Re: Planning Application 19/1031 and 1032

Address: Plots 1 and 2, 8 Hammond Drive Read BB12 7RE

Description: Proposed two-story dwelling house with integral garage, parking and drive access.

Plot 2
Site Layout & Sections

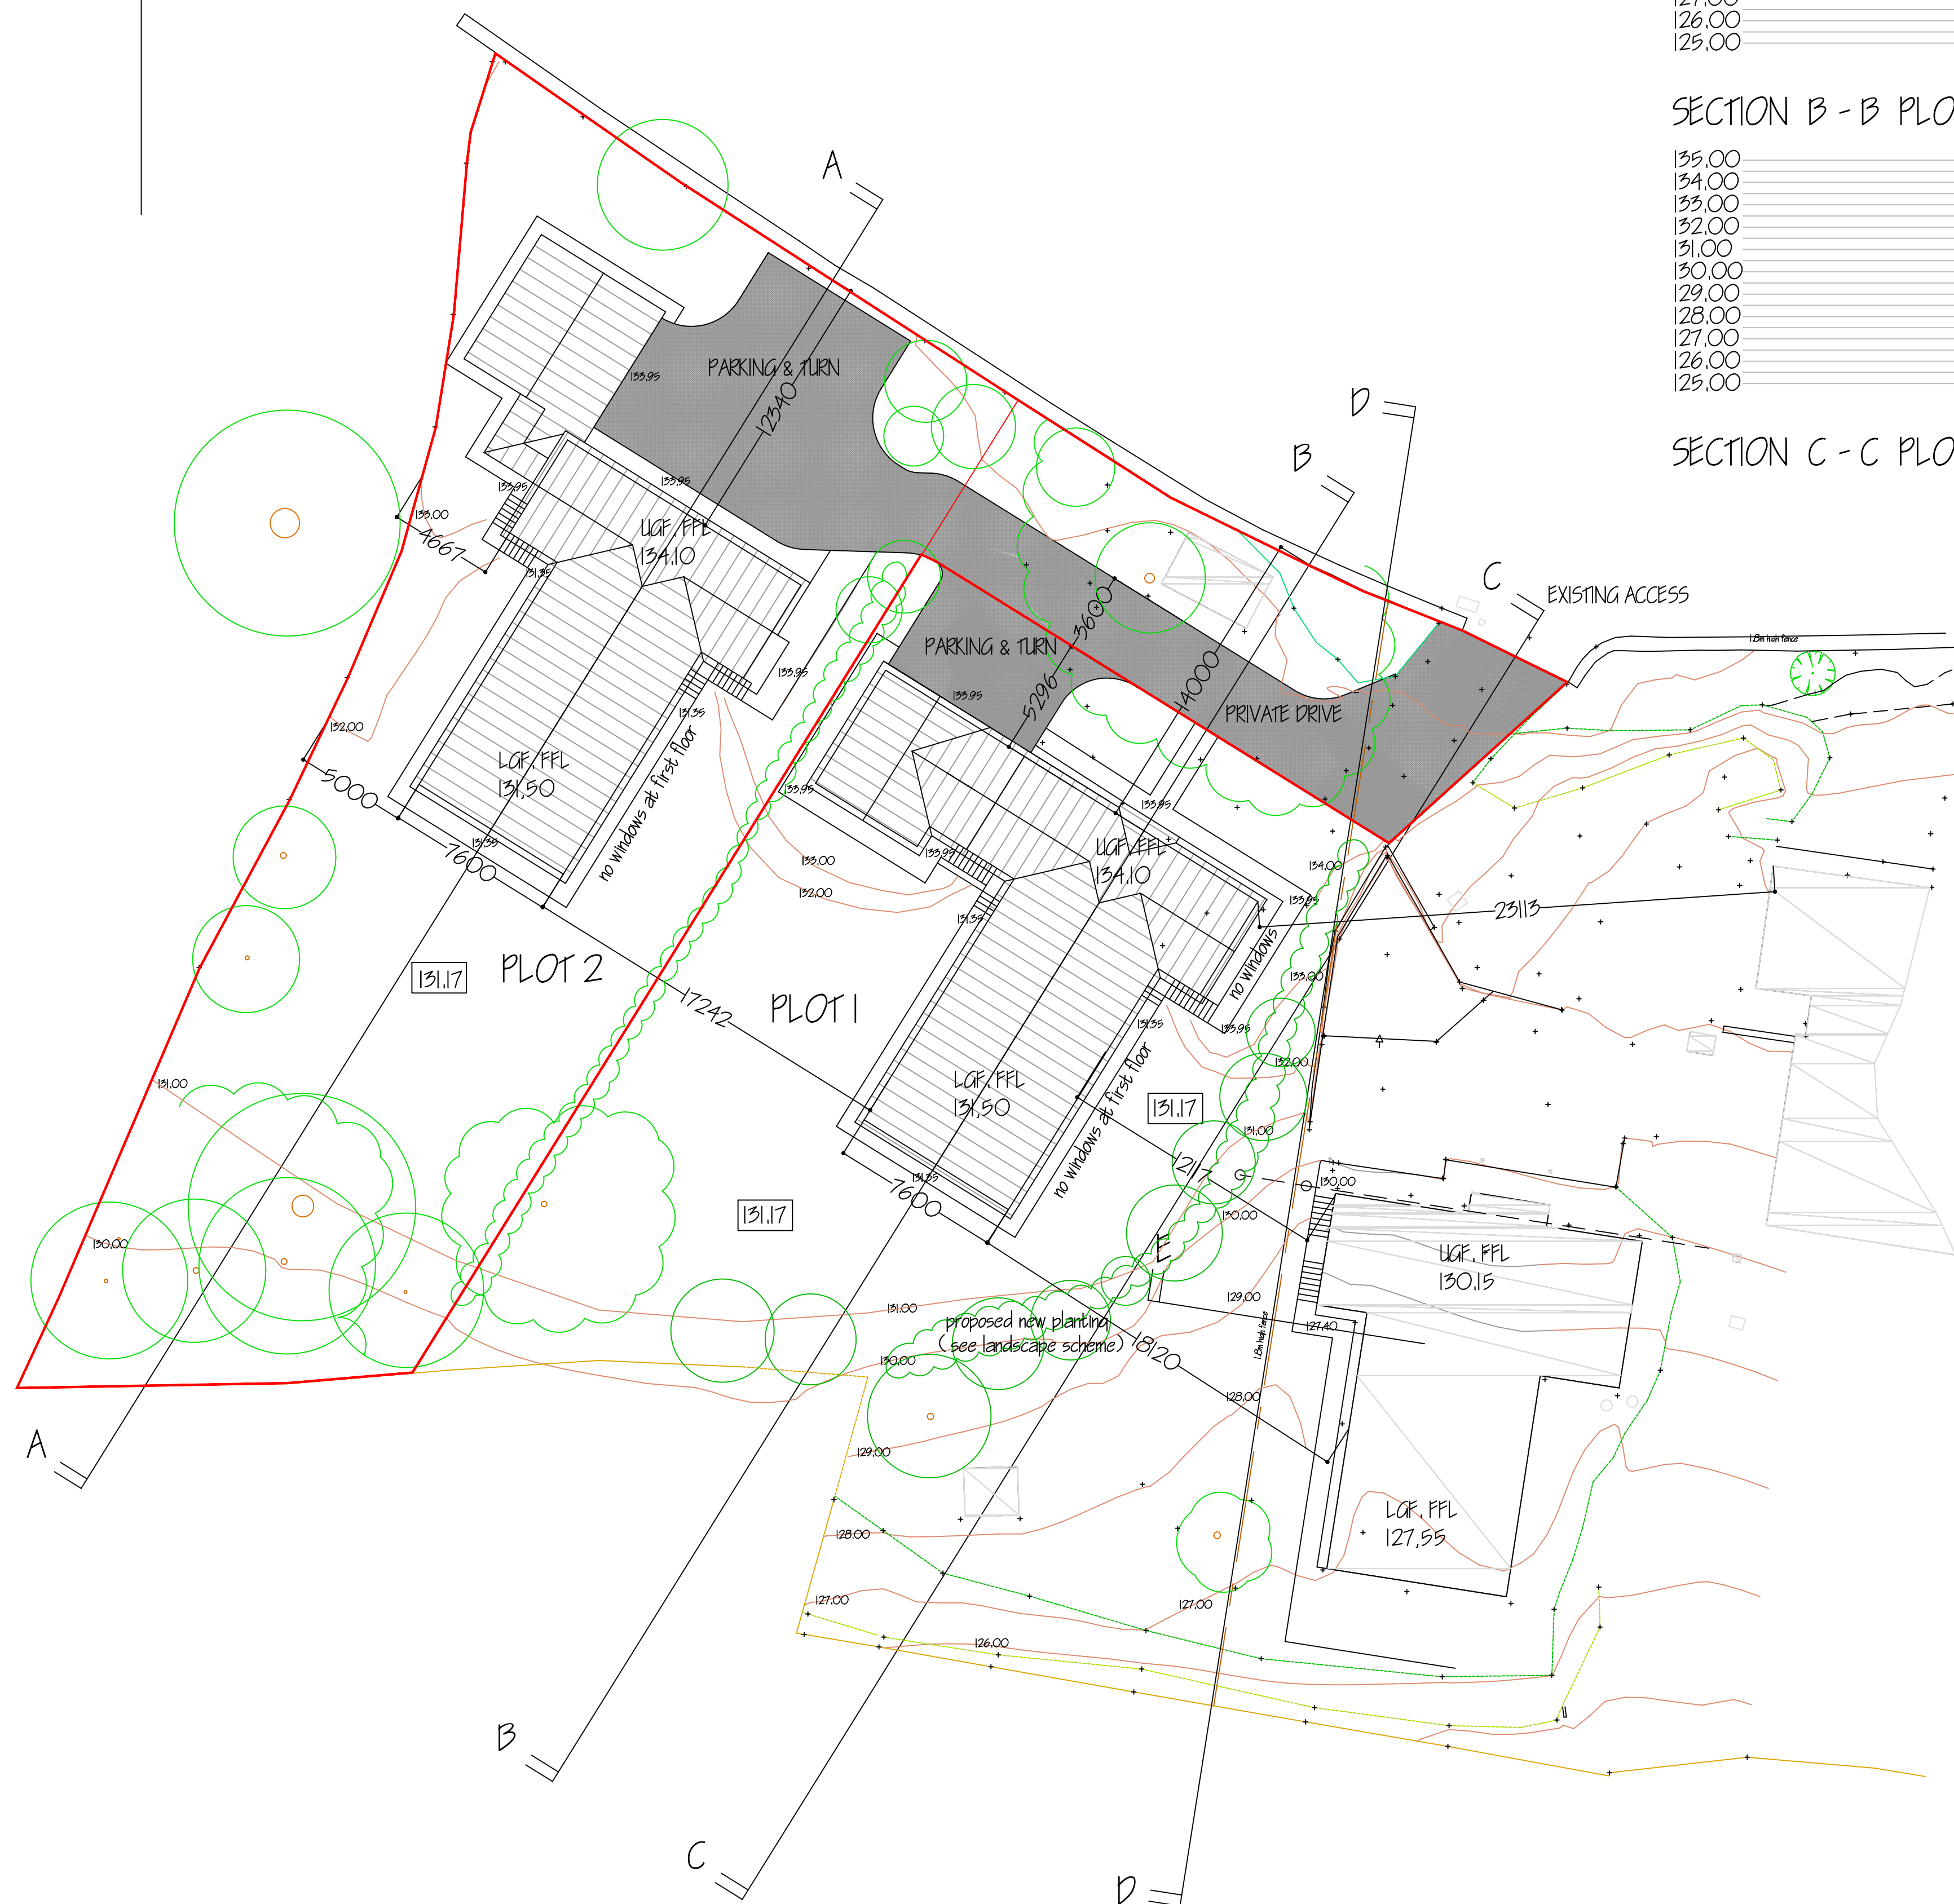
A further plan has been submitted No 1945/2/003 Rev B showing the widened drive with the swept paths showing the access arrangements are viable.

1. Before the access is used for vehicular purposes, that part of the access extending from the highway boundary for a minimum distance of 5m into the site shall be appropriately paved in tarmacadam, concrete, block pavements, or other approved materials. **Reasons:** To prevent loose surface material from being carried on to the public highway thus causing a potential source of danger to other road users.
